RE: Johnson-Hink Short Plat (SP-08-00035)

Holly Duncan
Environmental Health Specialist
Kittitas County Public Health
(509) 962-758

JOHNSON-HINK SHORT PLAT
PART OF SECTION 24, T. 17 N., R. 19 E., W.M.
KITTITAS COUNTY, WASHINGTON

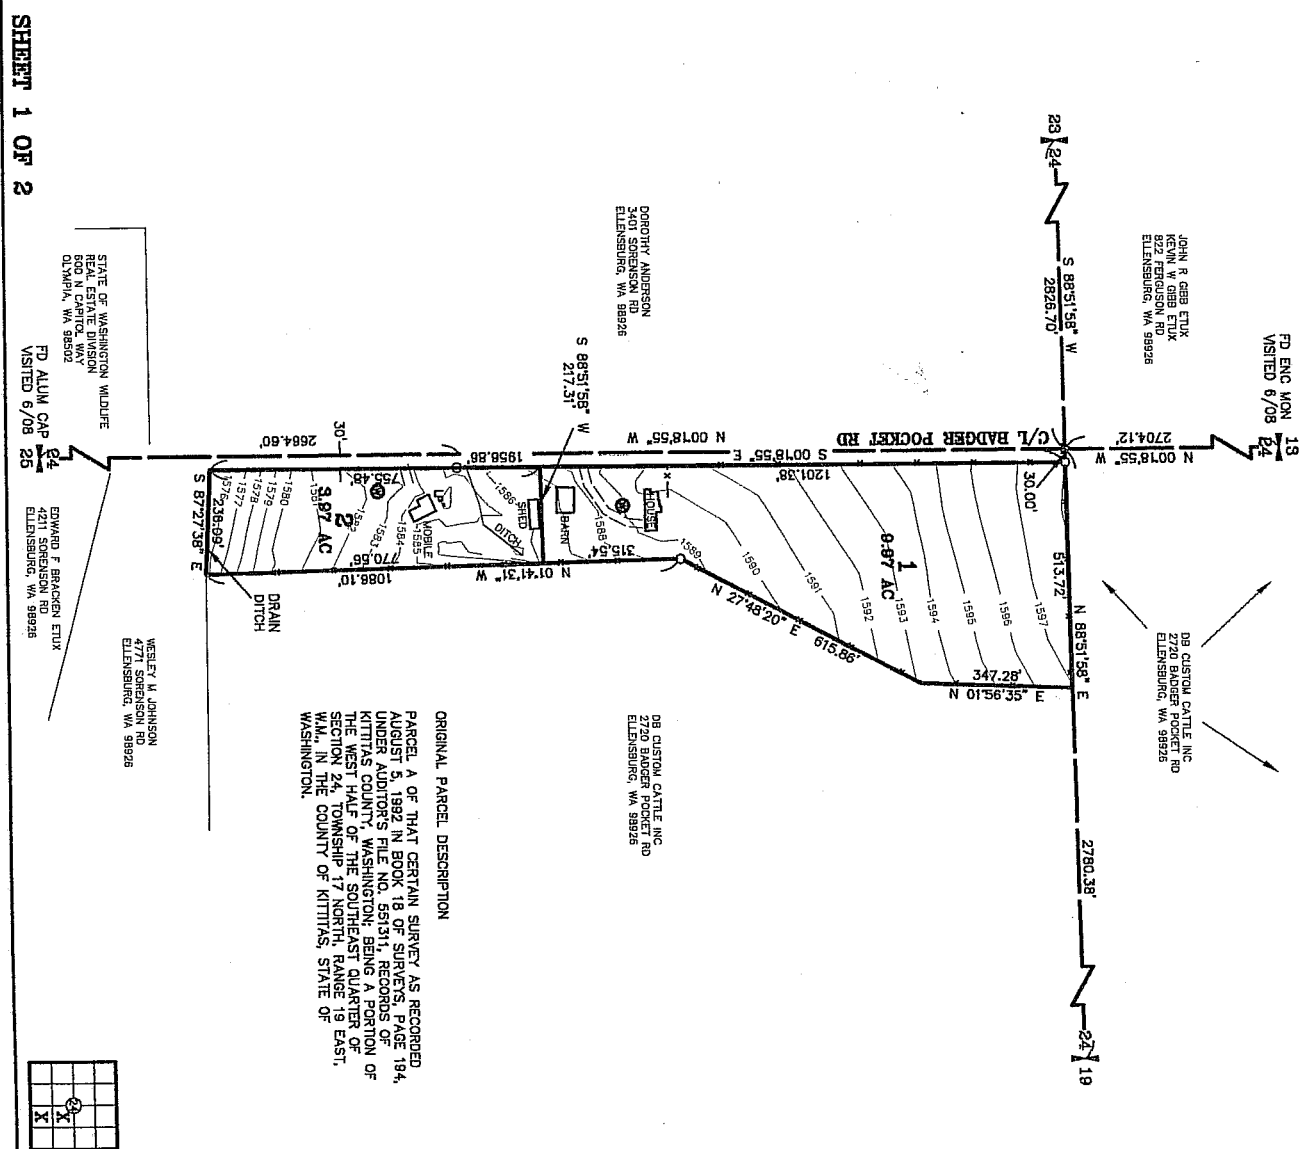
Thank you for the opportunity to comment on the above referenced project. The file indicates soil logs need to be performed and a well log is needed for one of the existing wells.
